21st May 2025

APPLICATION REF: REF: 2024/62/93079/E CHANGE OF USE AND ALTERATIONS TO CARE HOME UNIT 2 TO FORM 10 SELF-CONTAINED APARTMENTS AT THE RADCLIFFE, 444, HUDDERSFIELD ROAD, MIRFIELD, WF14 0EE

PROPOSED ELEVATIONS

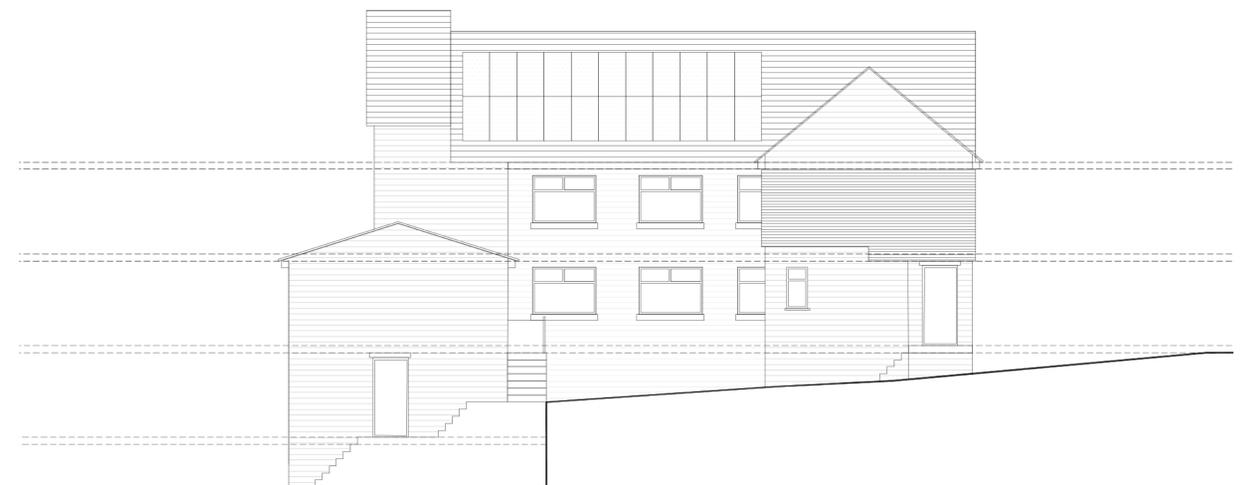
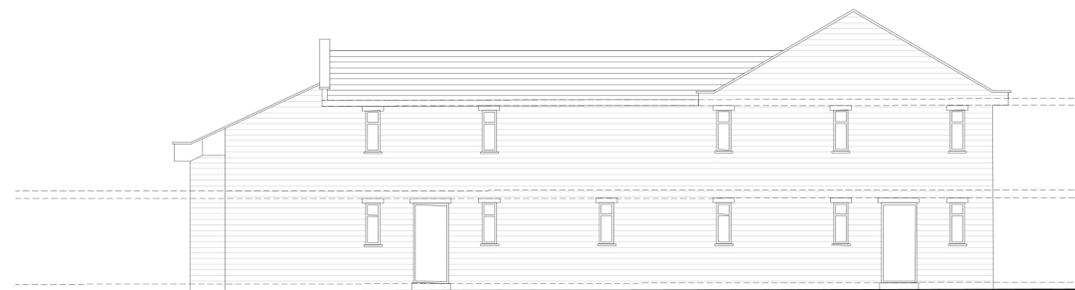
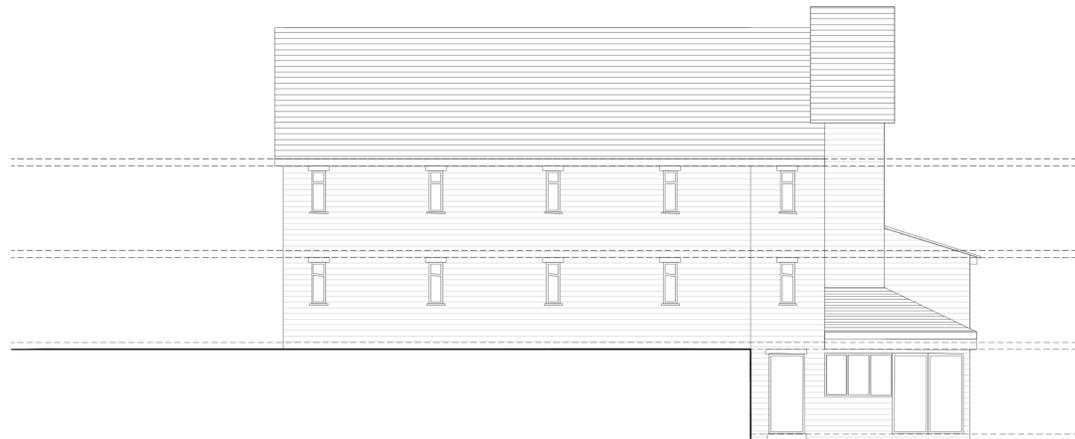
The application proposal seeks permission for a relatively small number of external alterations. The Proposed First Floor Plan Drawing Reference: 121850-08 shows that Apartment 9 is accessed via a new door opening and external steel staircase.

In undertaking that assessment, officers will need to be cognisant of the fact that my client’s property adjoins the application site in this location and will be directly overlooked by the proposed doorway and staircase. Whilst the topography is complex in this location, the proposed staircase and doorway afford direct views of doors, windows and private garden areas of neighbouring properties.

The current level of amenity enjoyed by my client is reasonable and proportionate for residential occupation. However, the activity, noise and overlooking of residents arriving and departing, as well as deliveries and other visitors to the property will have a significant detrimental effect on the levels of amenity experienced by my client.

The application proposals currently conflicts with policy LP24 of the Local Plan by virtue of the overlooking that it likely to occur as a result of this feature, as well as the significant disturbance and nuisance caused by the activity and lighting likely to occur as a reuse of the use of this new access. Consequently, planning permission should be refused on the basis of this policy conflict.
